Consultee response

Arun District Council Consultation - LU/91/19/PL - Coach Parking

Further to your comments (email dated 24 April 10:27) relating to coach parking the proposal is now to just use half of the coach parking area and to direct overspill coaches to Littlehampton Wave Leisure Centre where there are 2 further spaces. The applicants would like to apply for temporary use throughout the summer season as a whole.

SITE LOCATION PLAN AND
BLOCK PLAN - SITE C&D

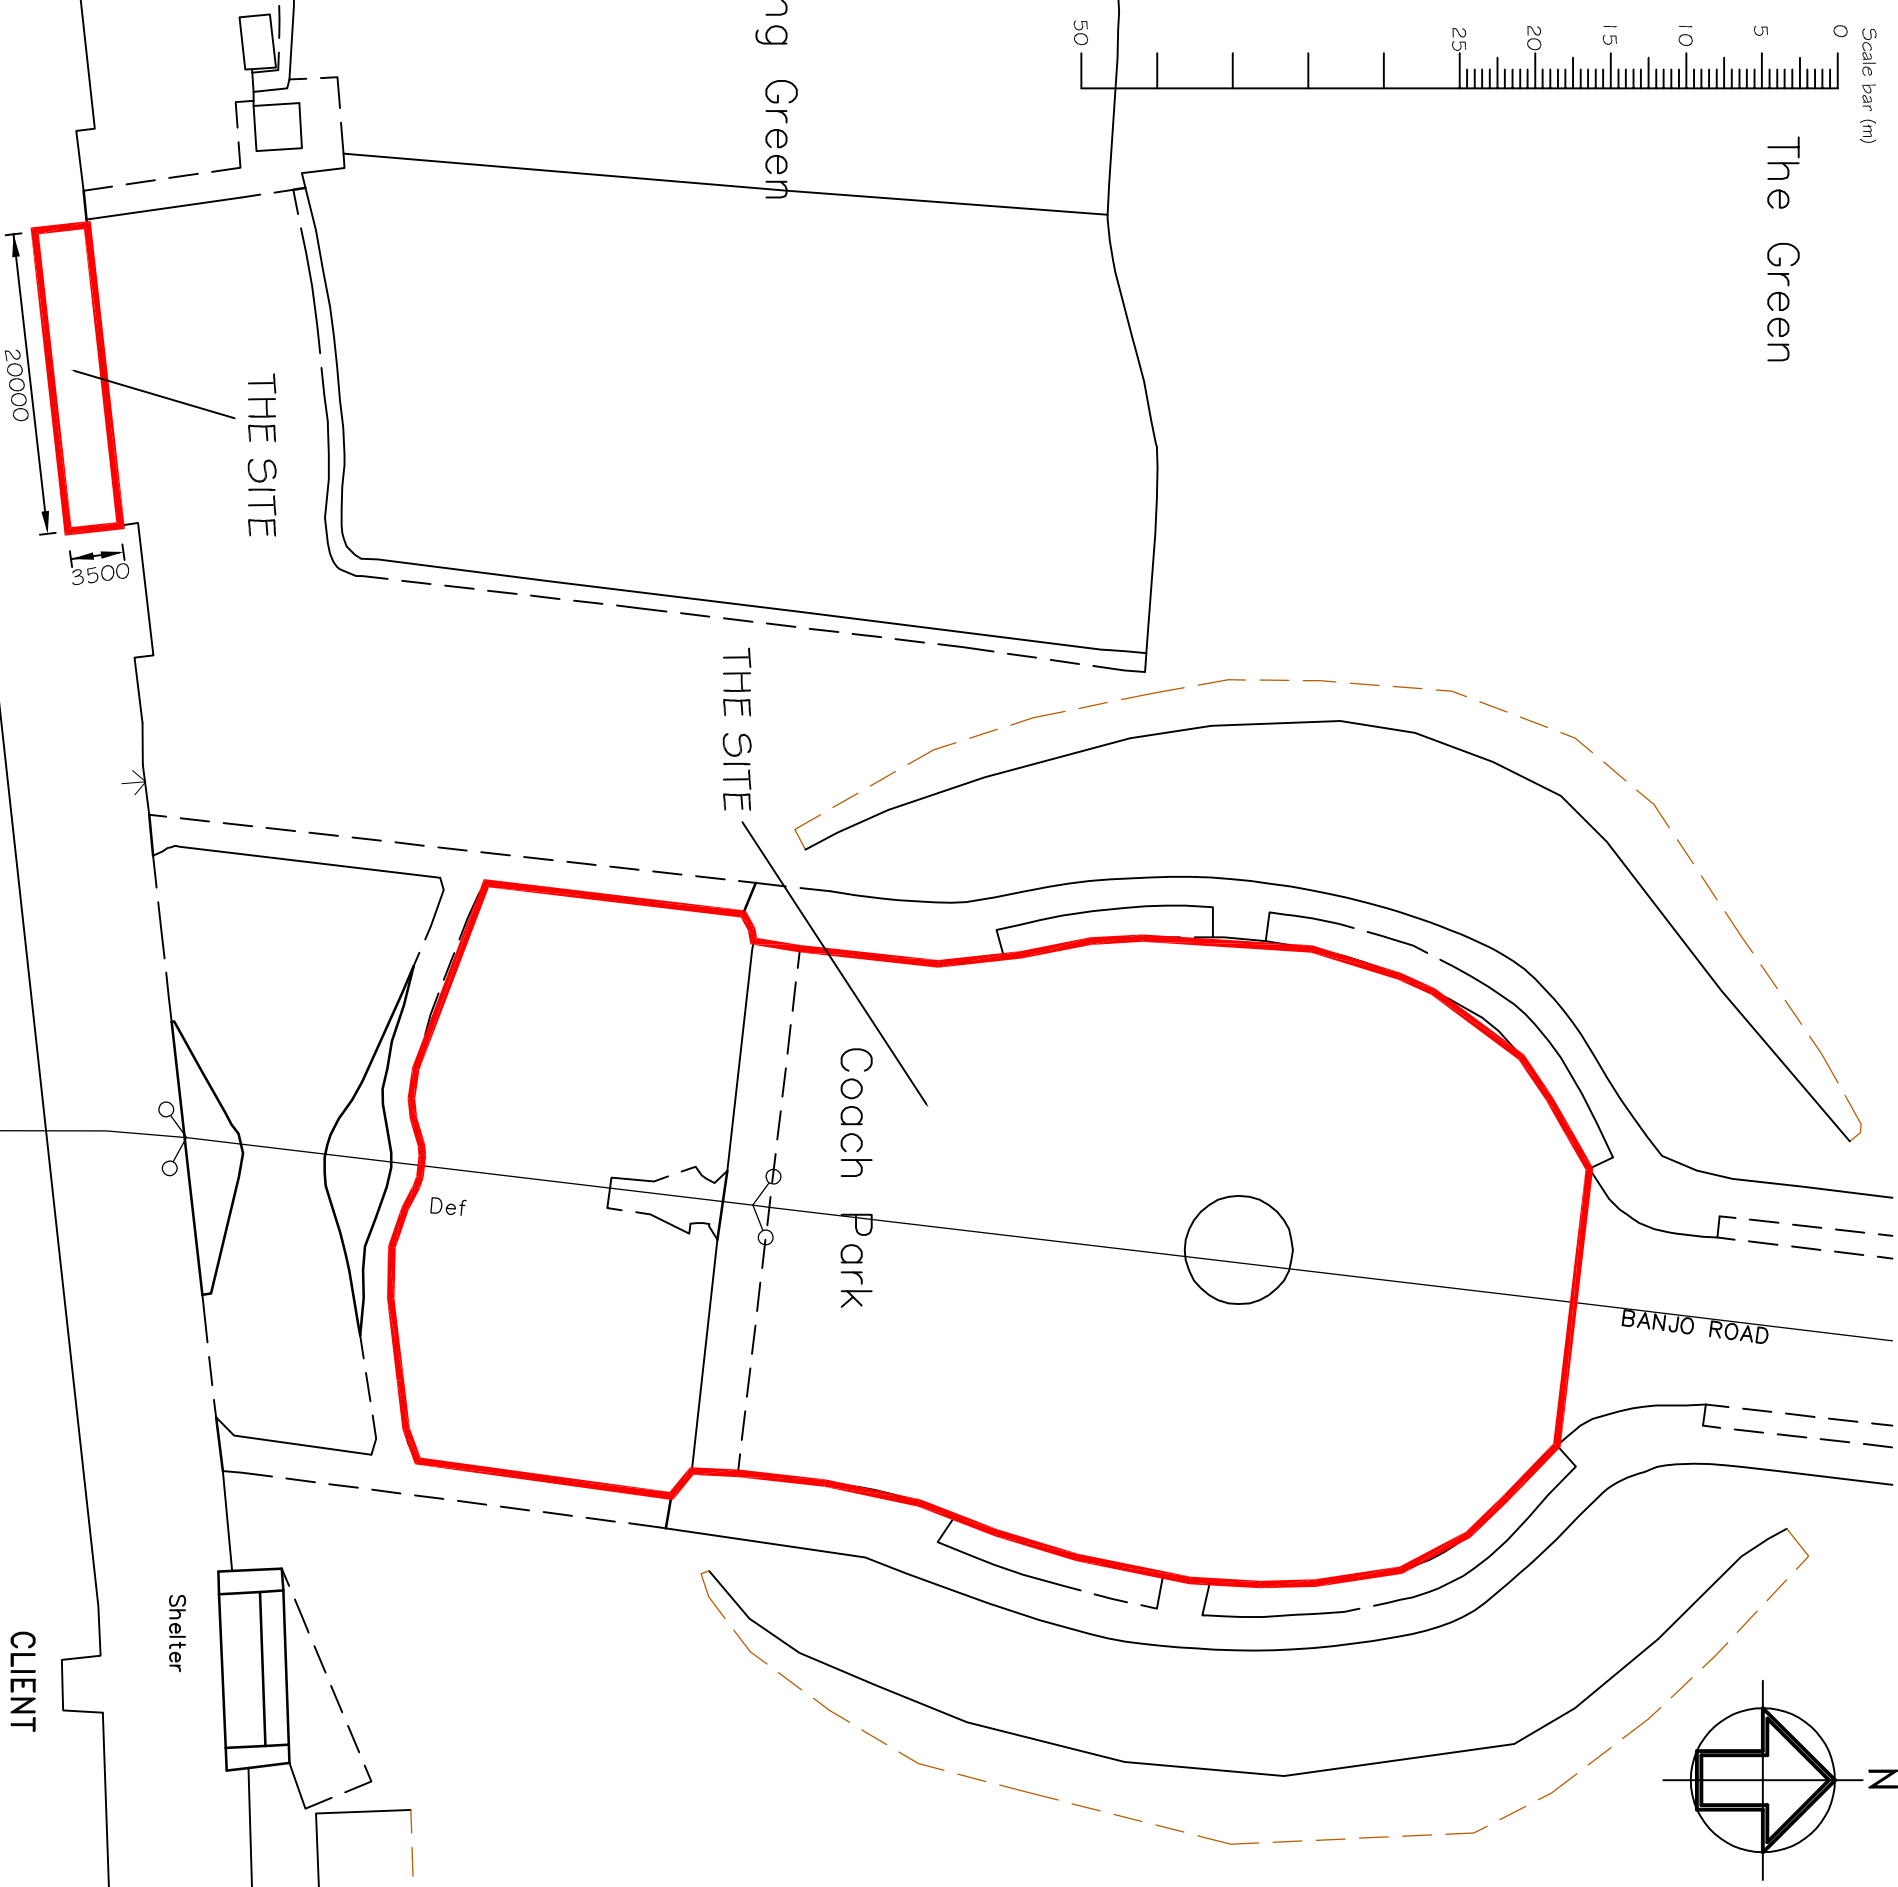
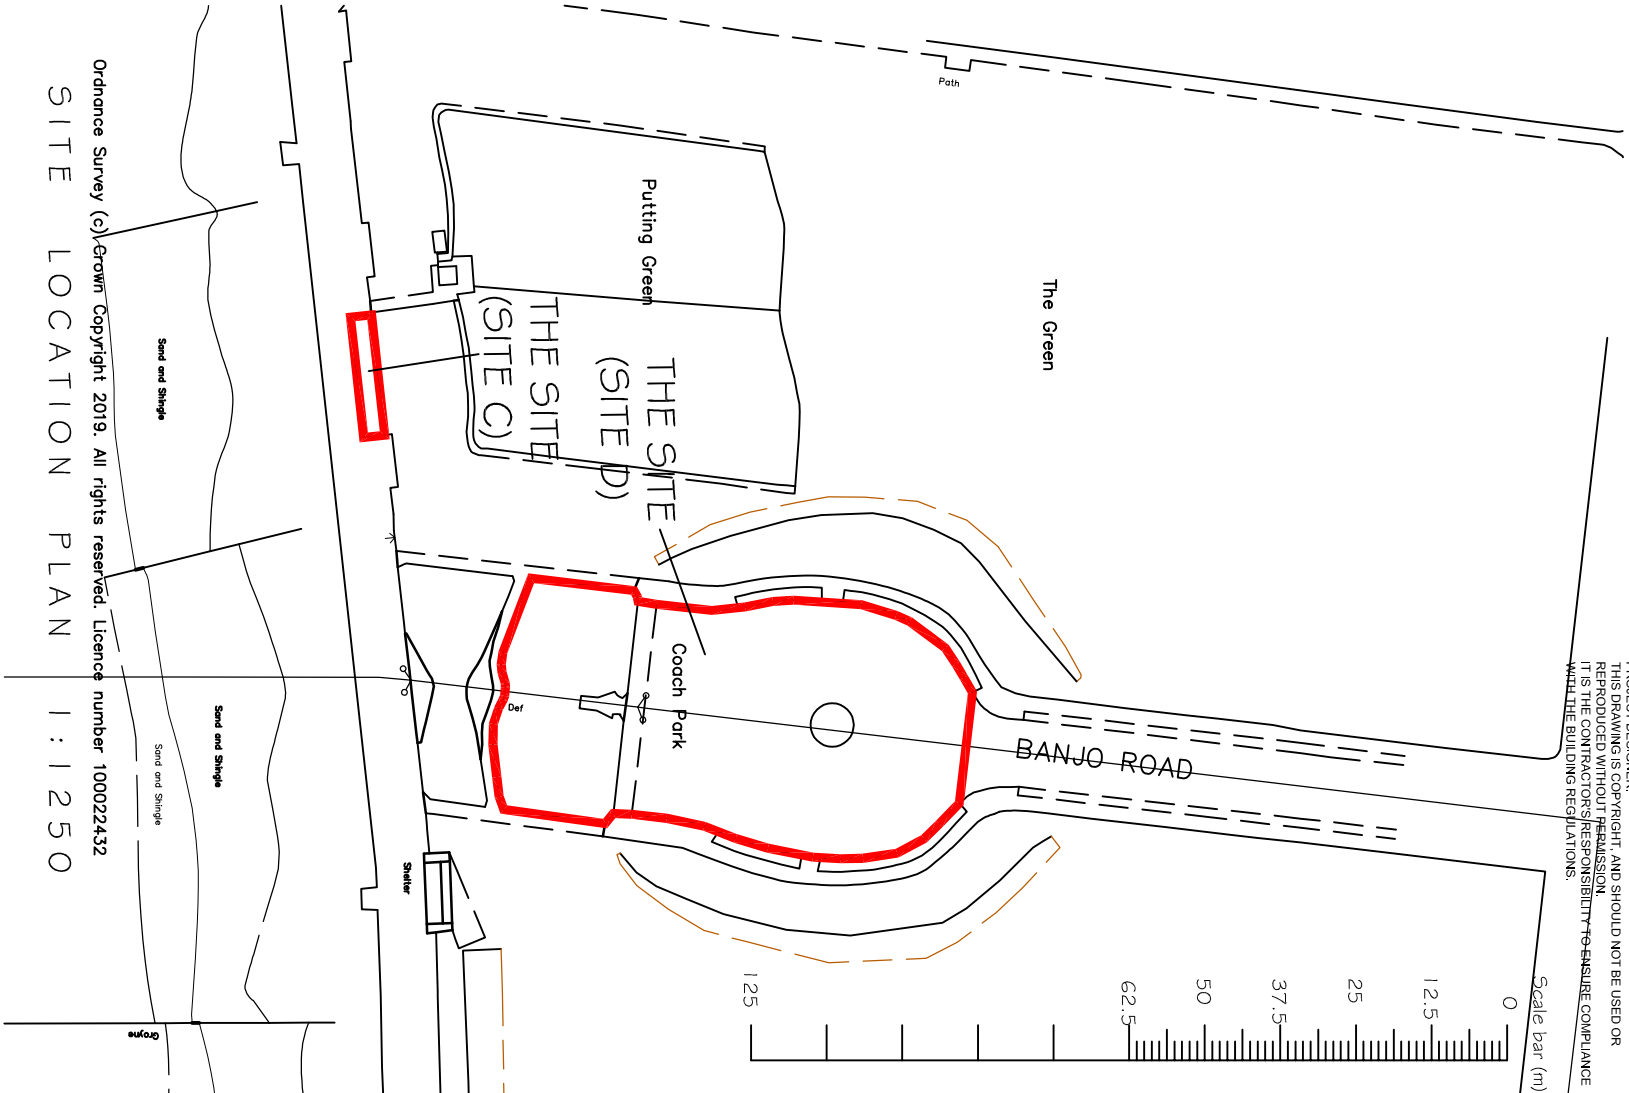
On the basis of only half the coach park now being used and the option to direct further coaches to the Leisure Centre the LHA would raise no concern to the temporary application. If however the whole coach park was to be used the applicant must provide evidence of where those displaced vehicles would park and appropriate signage would need to be used in consultation with WSCC Country Highways Planning and our Area Highway Office.

When further coach parking is identified, the rest of the site would be used following further consultation and approval from this Department.
